Application by Highways England for an Order Granting Development Consent for A57 Link Roads

Deadline 4 - response on behalf of High Peak Borough Council

Responses from High Peak Borough Council are provided in red to outstanding matters discussed in the hearing session held during the week commencing 7th February 2022.

**6.4 Environmental Statement  
Figure 5.4 Air Quality EU Compliance Risk  
Assessment**

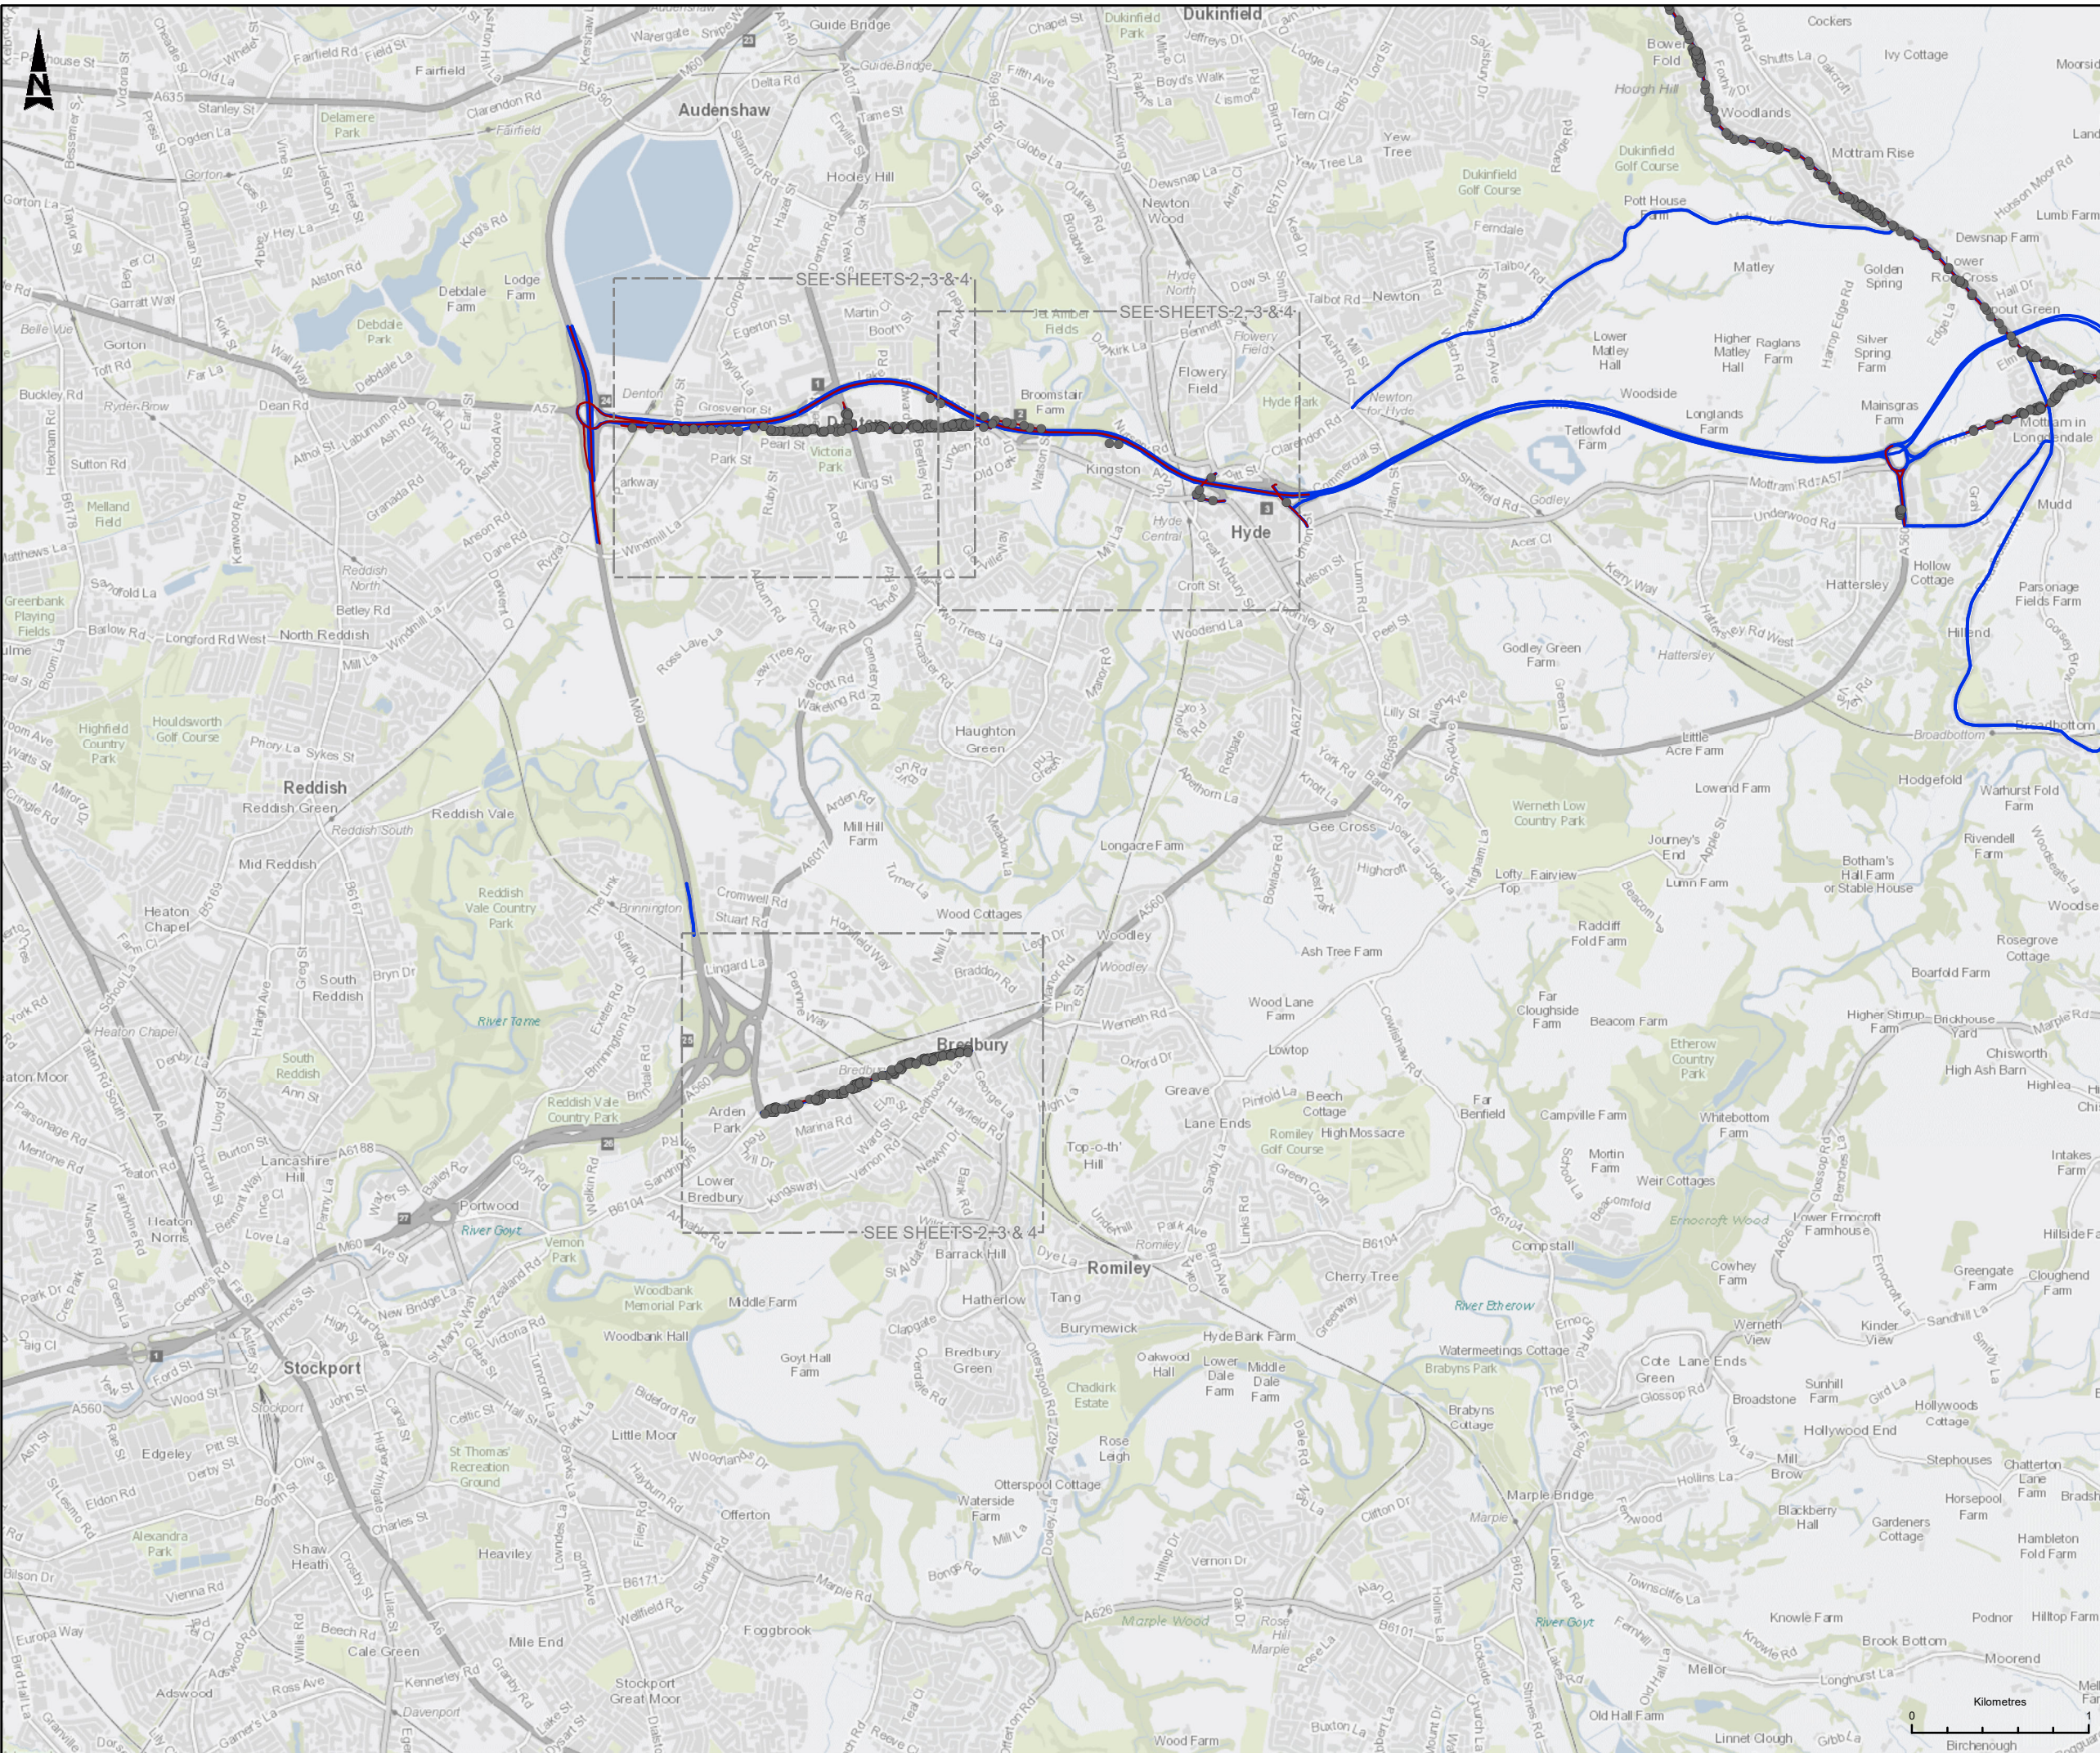
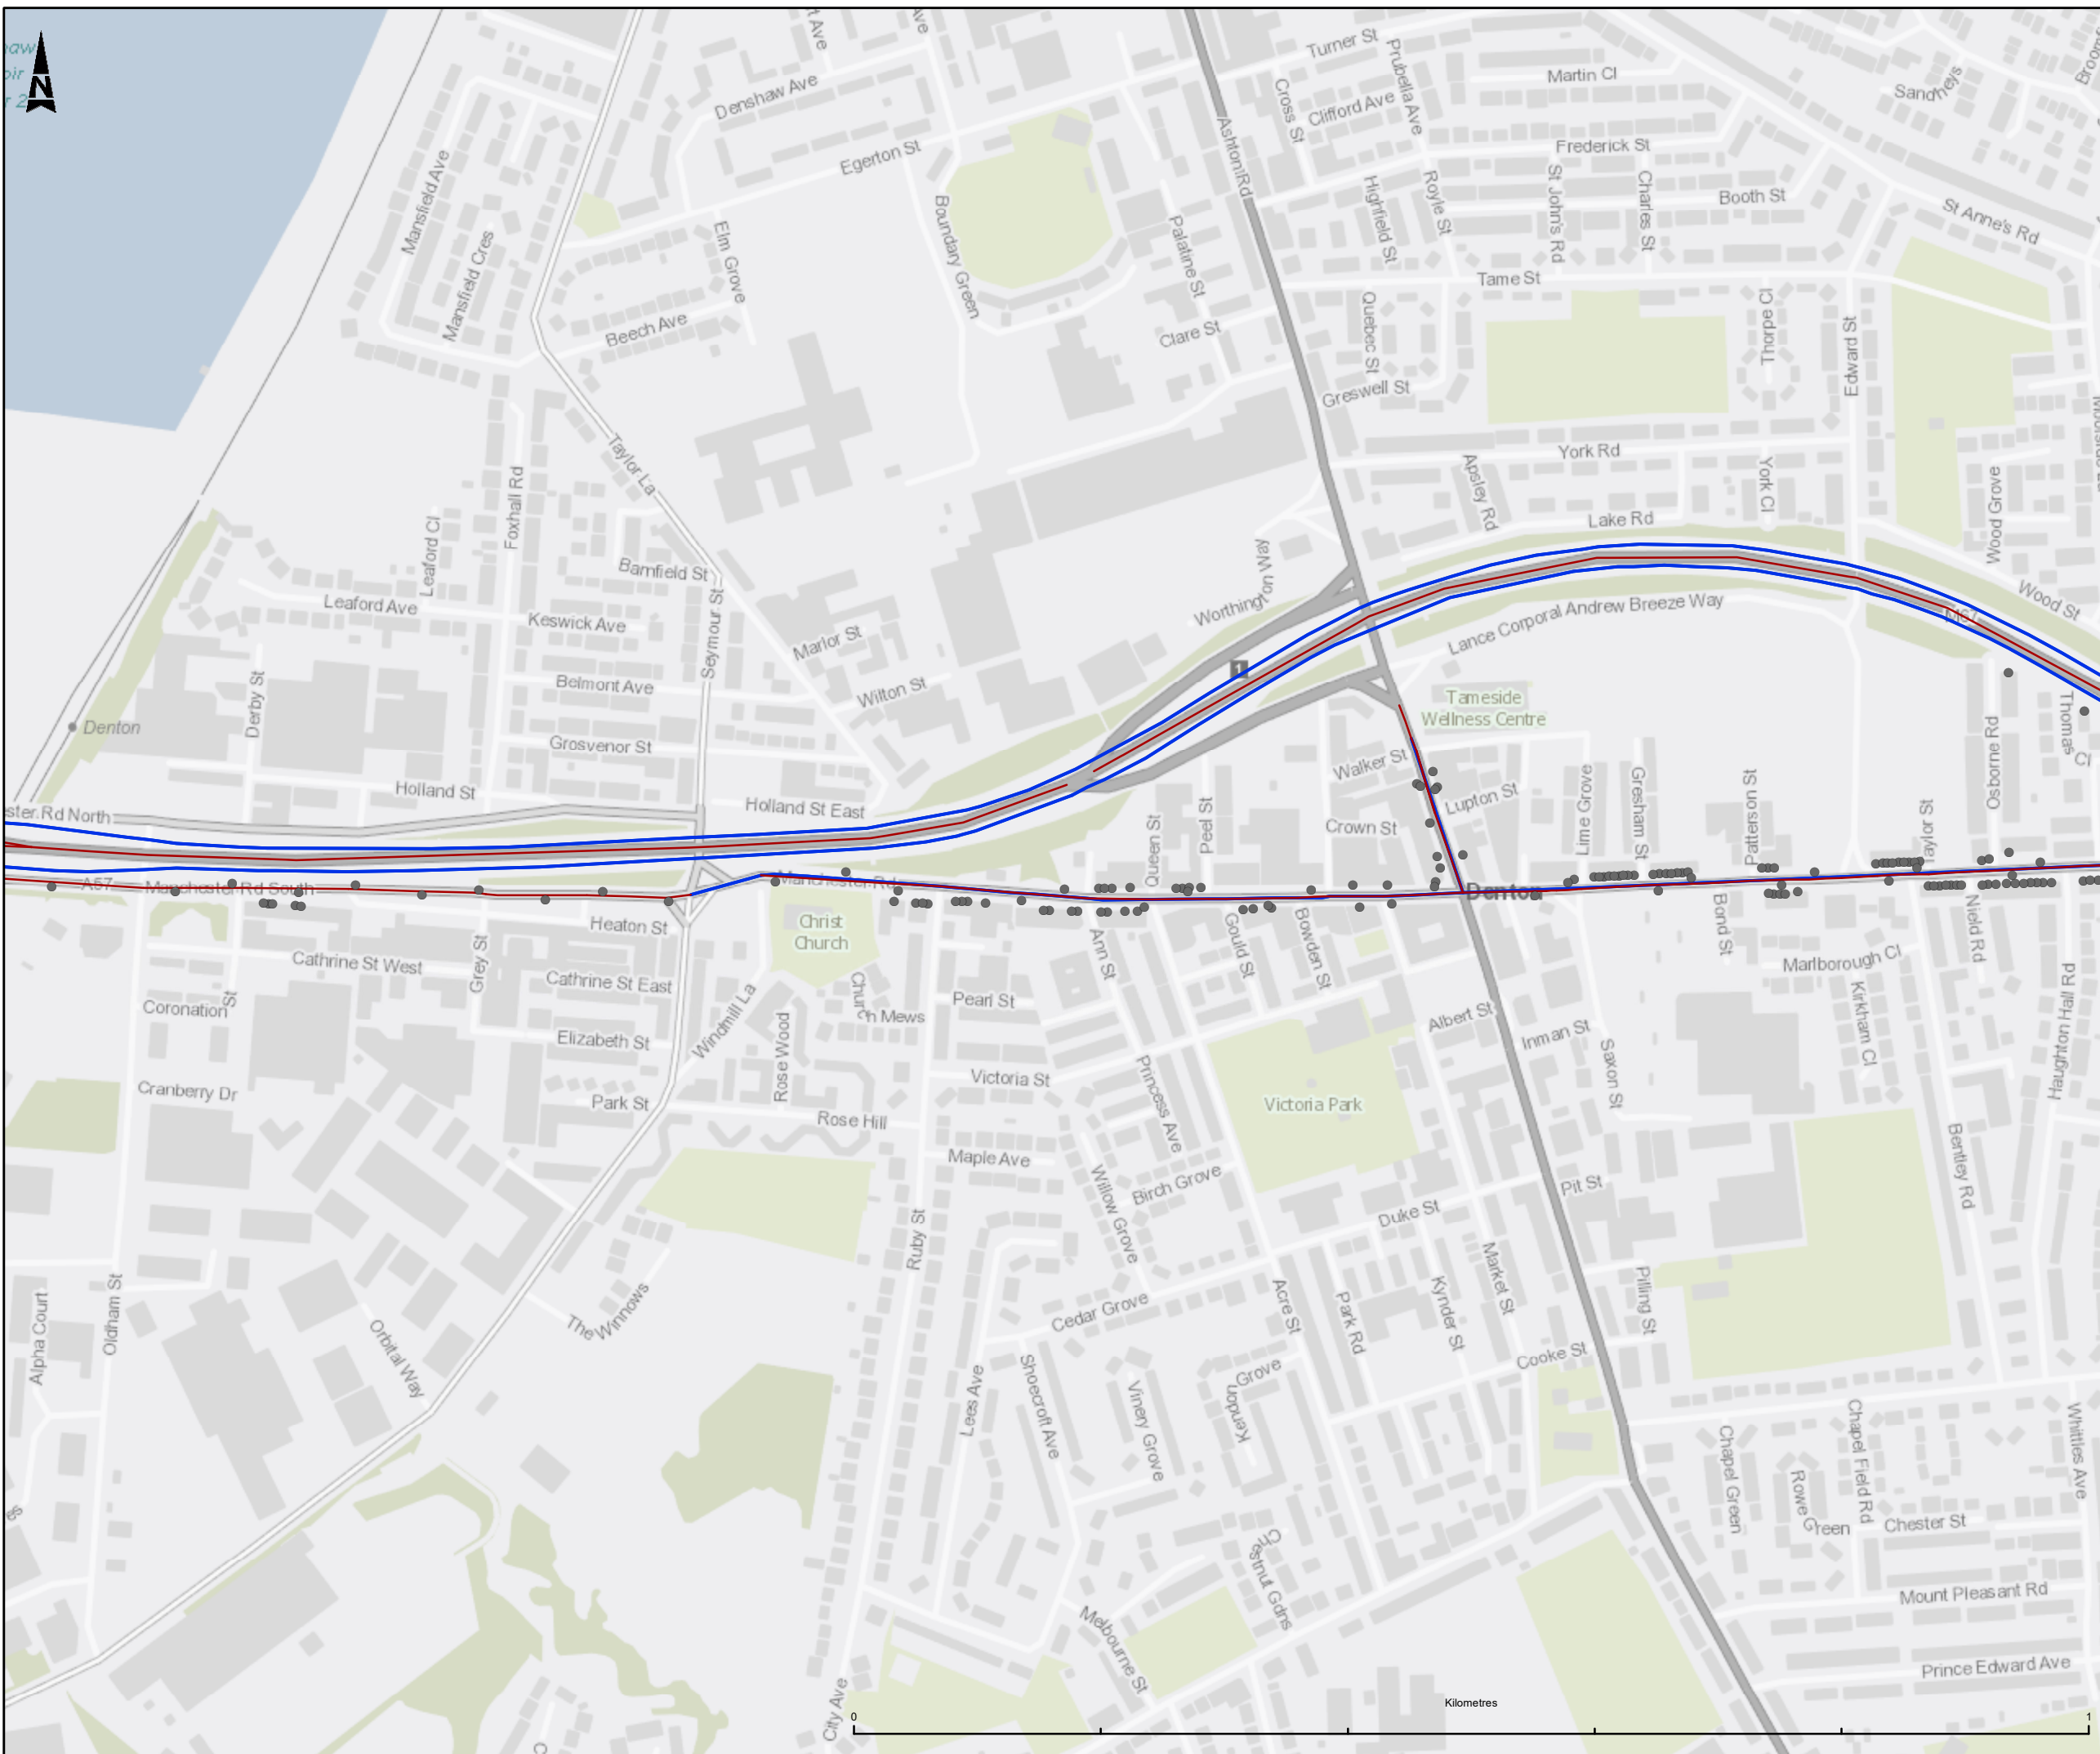
8.38 aa	Response is accepted with regards the details of dust control measures being set out in the EMP Nuisance Management Plan which will form an annex of the EMP (second iteration). The response however does not cover the second part of the issue, 'Qualifying features for the compliance assessment and receptors considered in the local air quality assessment along the A57 Brookfield are expected to show a large increase in NO2 concentrations in the opening year. The qualifying features for the compliance assessment are not labelled on Figure 5.4'
